From: Amanda Scholes on behalf of Planning.Responses
Sent: 24 April 2018 08:30
To: Planning Scanning
Subject: FW: Planning Consultation on: BN/6/18/RES

Comments relating to surface water drainage:

APPLICATION **BN/6/18/RES**

Description of Works: Approval of reserved matters following outline consent BN/32/15/OUT relating to appearance, landscaping, layout & scale for erection of 38 No. dwellings including open space, landscaping & new access (resubmission following BN/28/17/RES).

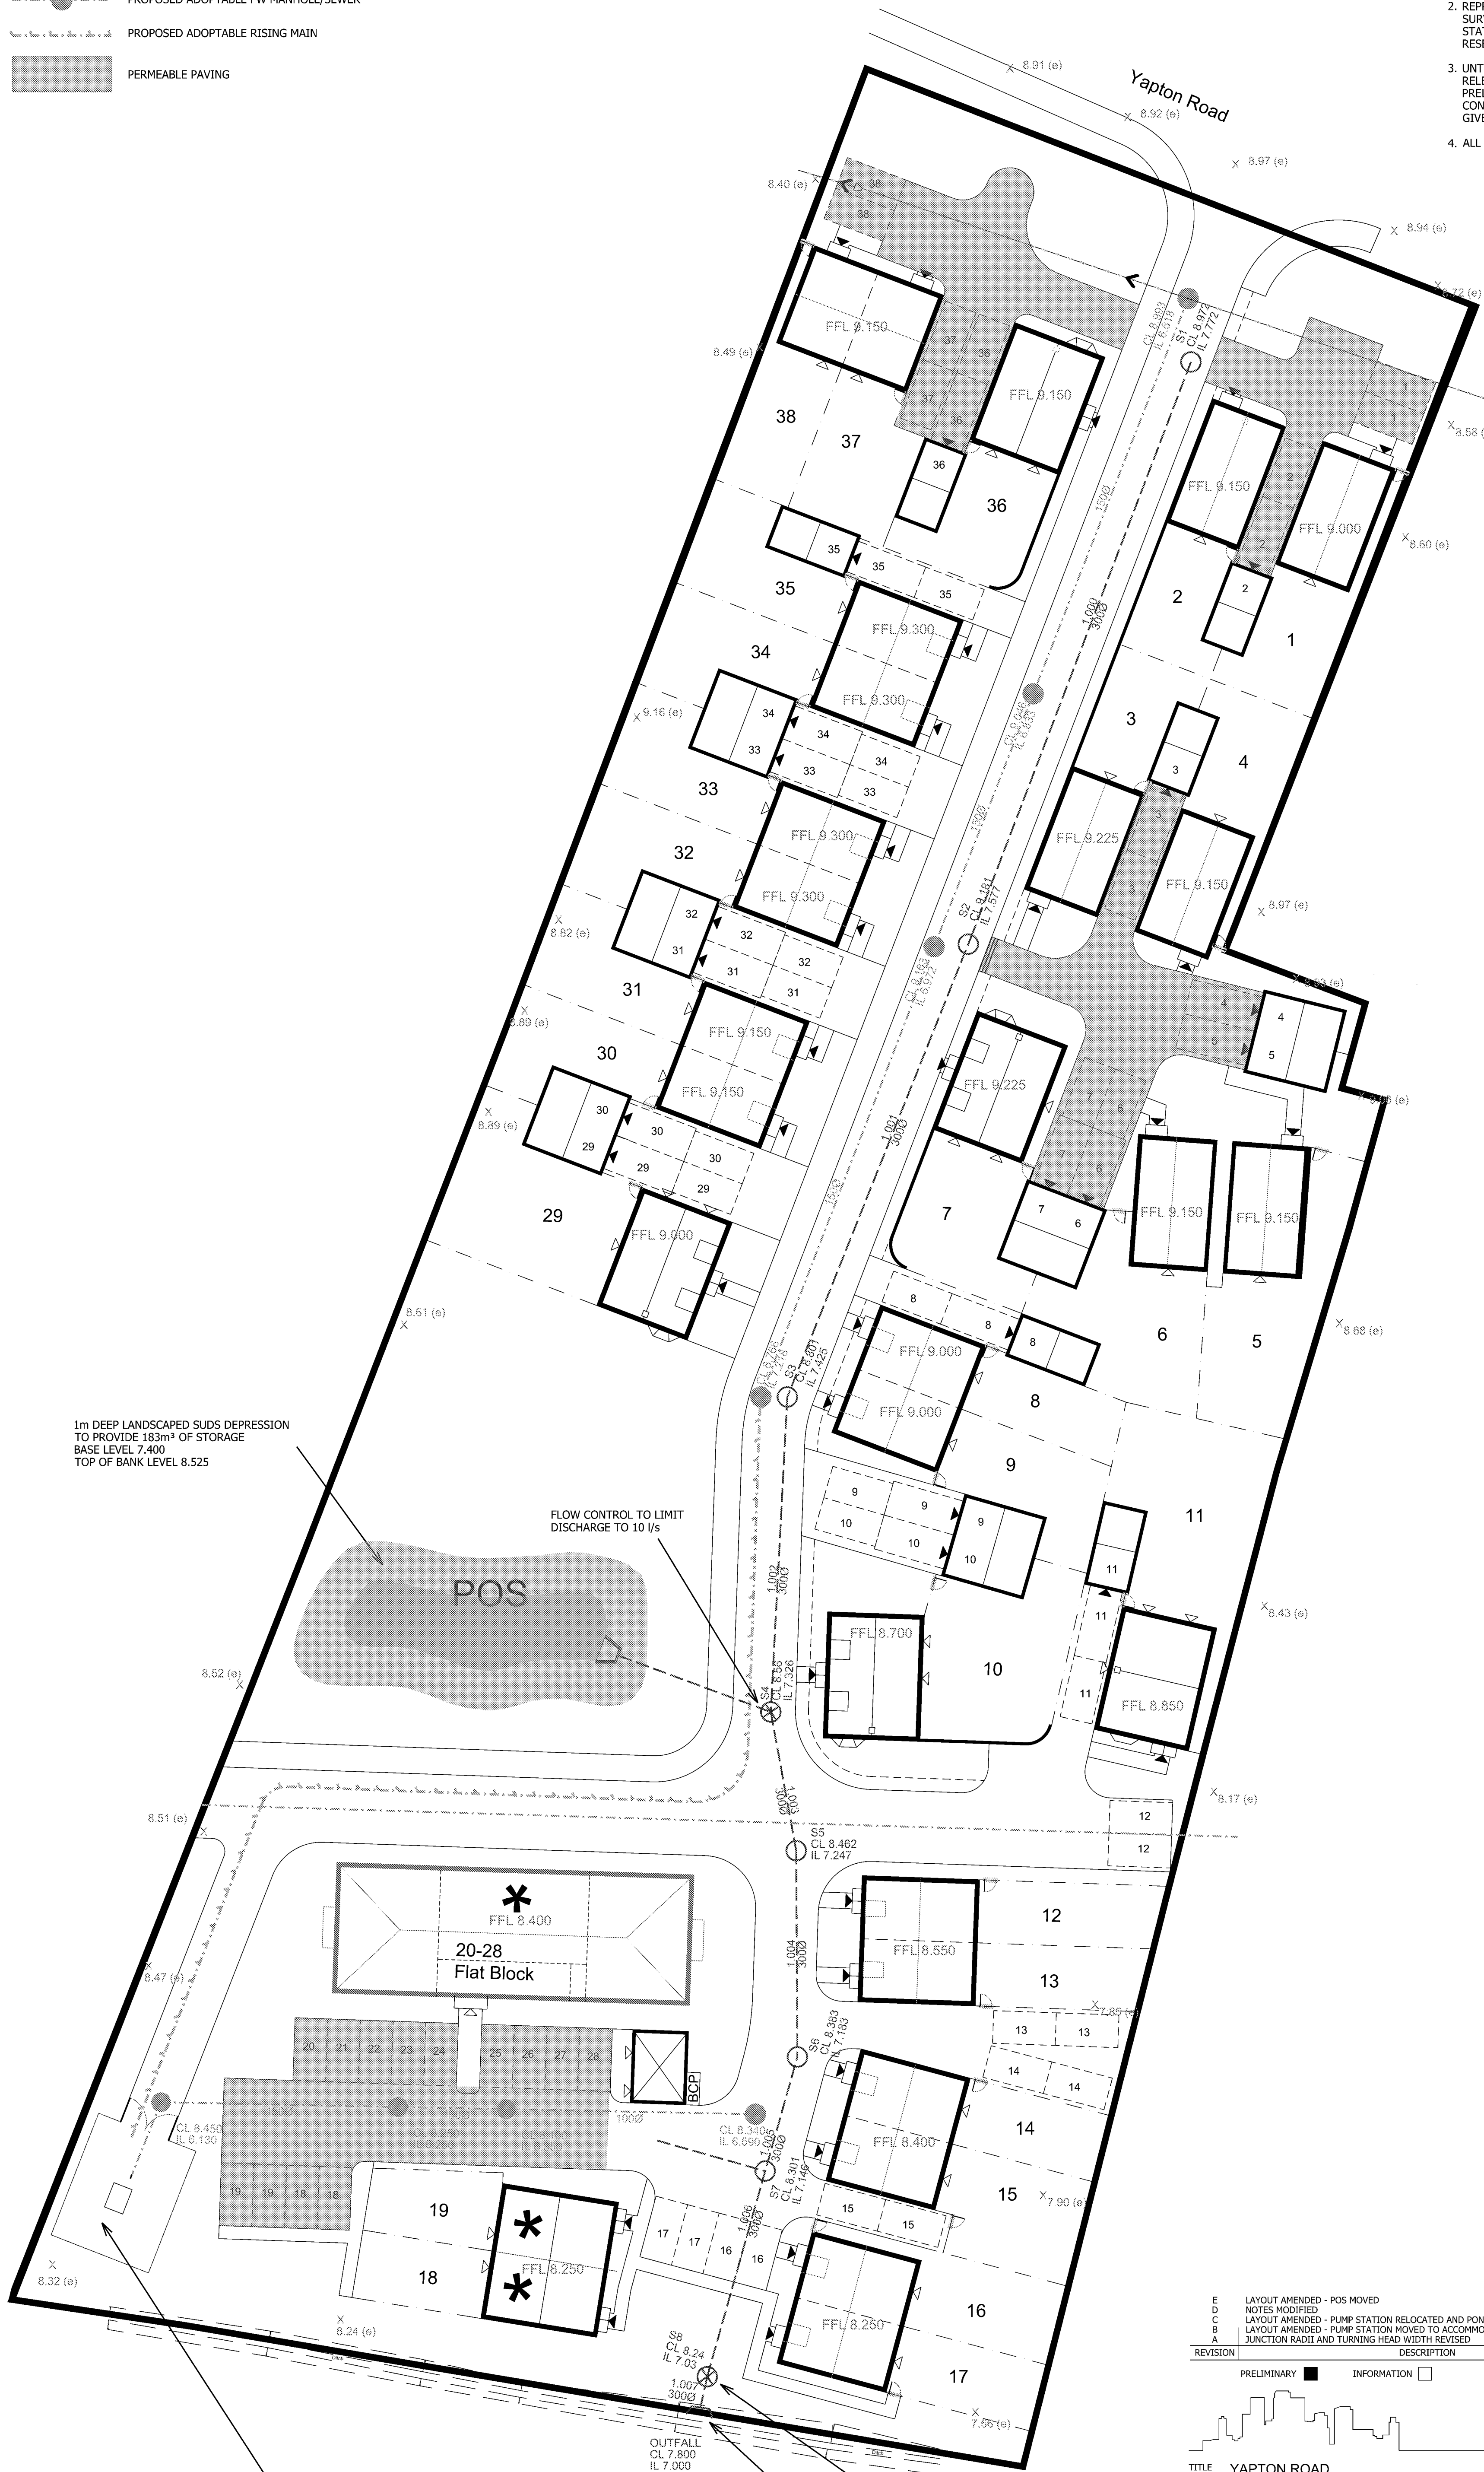
- The discharge rate from the site will need to be limited to the 1 year greenfield runoff rate of 2.9l/s.
- More permeable paving areas are required, i.e. permeable paving for all parking areas. This is to ensure sufficient treatment is achieved.
- Could the storage pond be made online rather than offline, with a low flow channel through the middle?
- Re-grading of the ditch downstream will be required.
- A minimum of 3m easement to all ditches is required to enable future maintenance.
- Full construction detail drawings will need to be submitted with formal DOC applications.
